SUBMISSION IN OBJECTION

to An Coimisiún Pleanála

Proposed Maughanaclea Renewable Energy Development

Submitted by	Wild Hideaways Eco Spa Retreat
Address	Wild Hideaways, Mealagh Valley, Co. Cork
Email	info@wildhideaways.ie
ACP Reference	ACP-324165-26
Applicant	Maughanaclea Ltd. (associated company of Enerco Energy Ltd.)
Development	14 wind turbines (169m tip height), substation and associated works, Maughanaclea and adjacent townlands, Co. Cork
Date	May 2026

Figure 12-11 and Figure 12-12 show the derived daytime and night-time background noise level for NML 4 filtered from South winds.

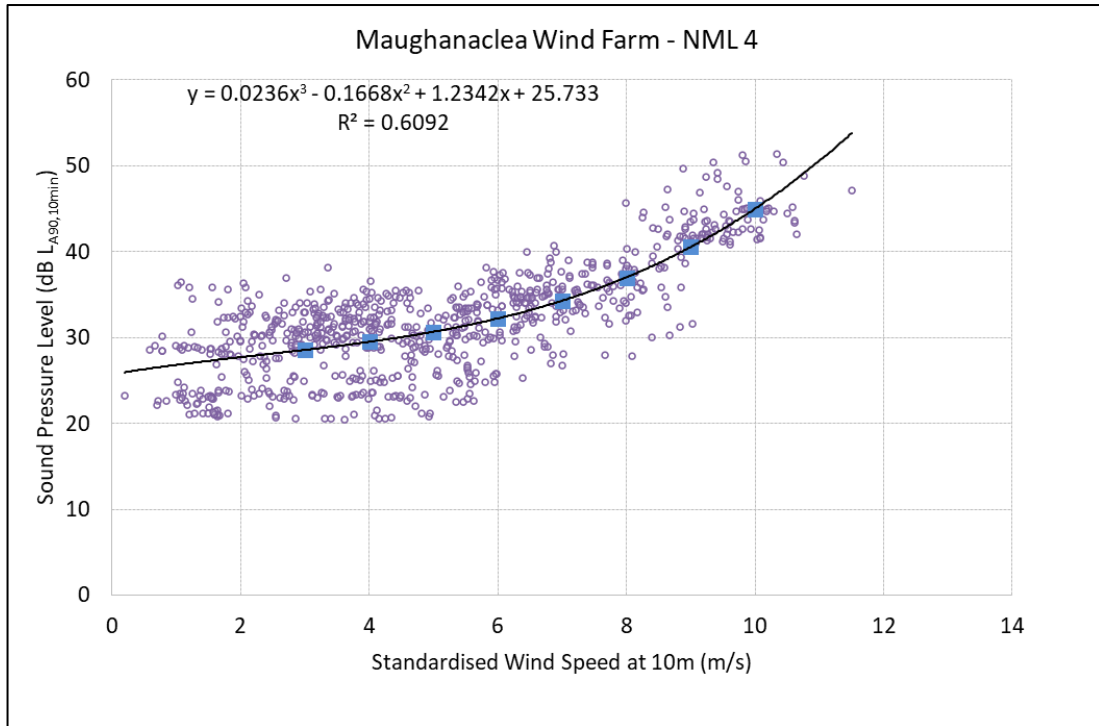
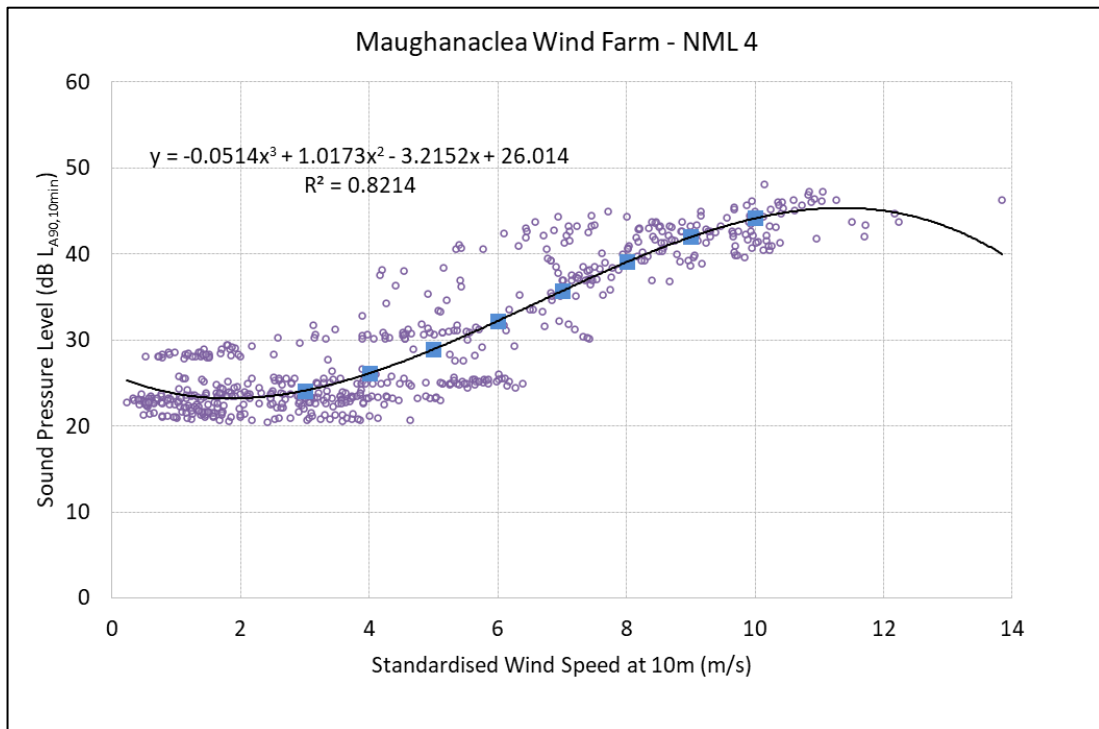
- NML4 (H041) — the nearest monitoring location to Wild Hideaways — is 3,014m from Wild Hideaways, approximately 1km further from the property than the nearest turbine
- NML3 (H015): 3,571m from Wild Hideaways
- NML5 (H031): 4,016m from Wild Hideaways
- NML1 (H014): 5,912m from Wild Hideaways
- NML2 (H003): 7,984m from Wild Hideaways
- NML6 (H018): 8,578m from Wild Hideaways

Wild Hideaways is therefore closer to the turbines than every single noise monitoring location, yet was never assessed. The developer's own noise consultants acknowledge background noise levels in the area are very low (Chapter 12, Section 12.5.3.1, page 12-44). Night-time backgrounds as low as 23.4 dB LA90 were recorded at NML2. Wild Hideaways, in an enclosed valley position further from roads, would almost certainly record even lower backgrounds. At such levels, even a modest turbine noise contribution represents a highly significant proportional increase in the acoustic environment.

Figure 14-20: National monuments and Preservation Orders within 10km study area.

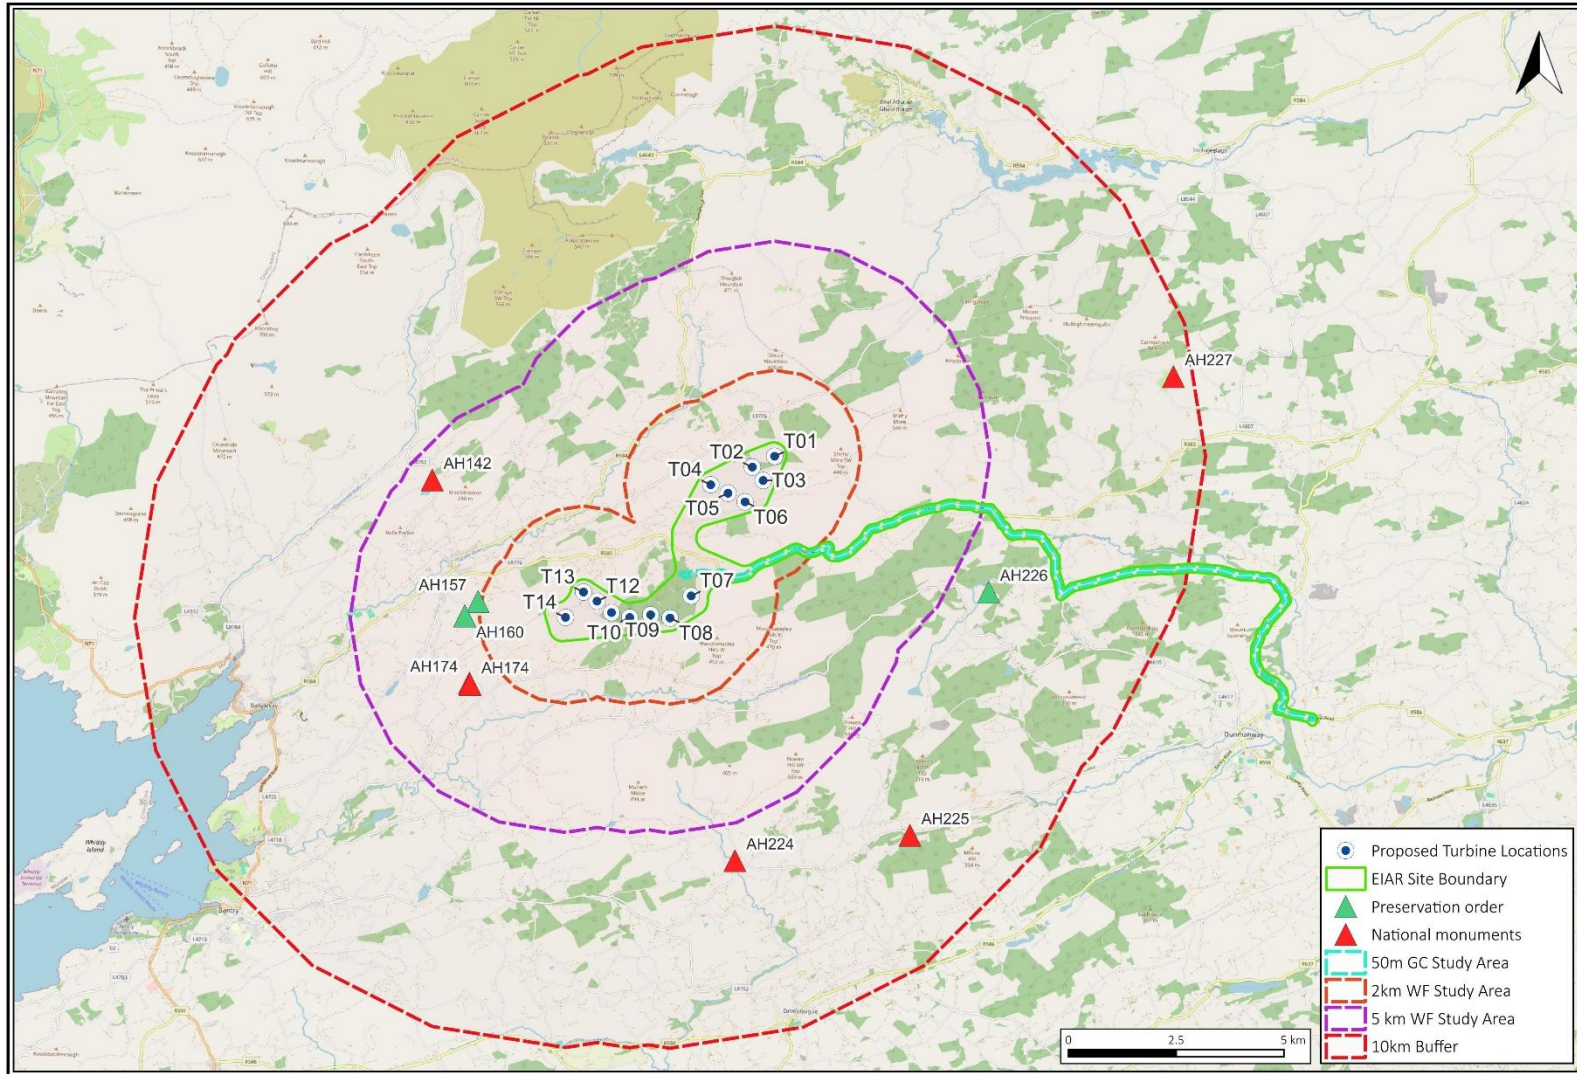
The Kealkill Stone Circle (Preservation Order PO No. 69/1938, approximately one mile from Wild Hideaways) is integral to our dark sky tourism offering. The developer’s own Cultural Heritage assessment concedes that “effects on the setting of the sites cannot be mitigated” (Chapter 14, Section 14.4.5, page 14-67) — a direct admission of irreversible harm to a nationally protected monument.

Figure A12-2-3. Final Study Area – 30 dB LA90 Contour for Maughanaclea

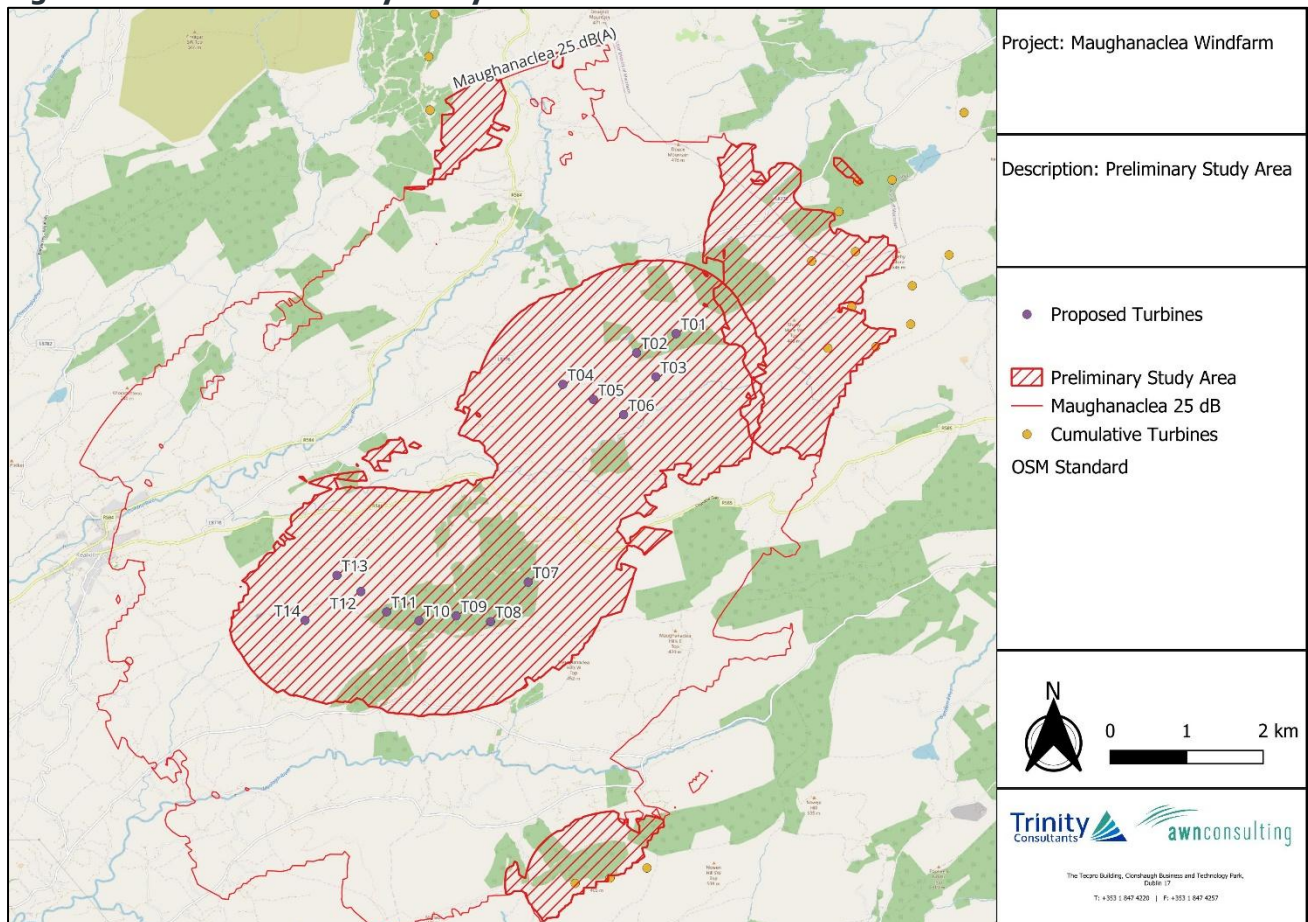
Wild Hideaways is not included as a Noise Sensitive Location (NSL) in the noise modelling despite meeting the developer's own definition precisely. The applicant's Glossary of Acoustic Terms (Appendix 12-1, page A12-1-1) defines an NSL as "any dwelling house, hotel or hostel, health building, educational establishment, place of worship or entertainment, or any other facility or other area of high amenity which for its proper enjoyment requires the absence of noise at nuisance levels." Wild Hideaways meets this definition unambiguously.

AWN Consulting Ltd assessed 279 NSLs (H001-H279) listed in Appendix 12-3. Wild Hideaways, at ITM E506,507 / N553,472, does not appear anywhere in this list. Every single one of the six noise monitoring locations is further from the southern turbine cluster than Wild Hideaways:
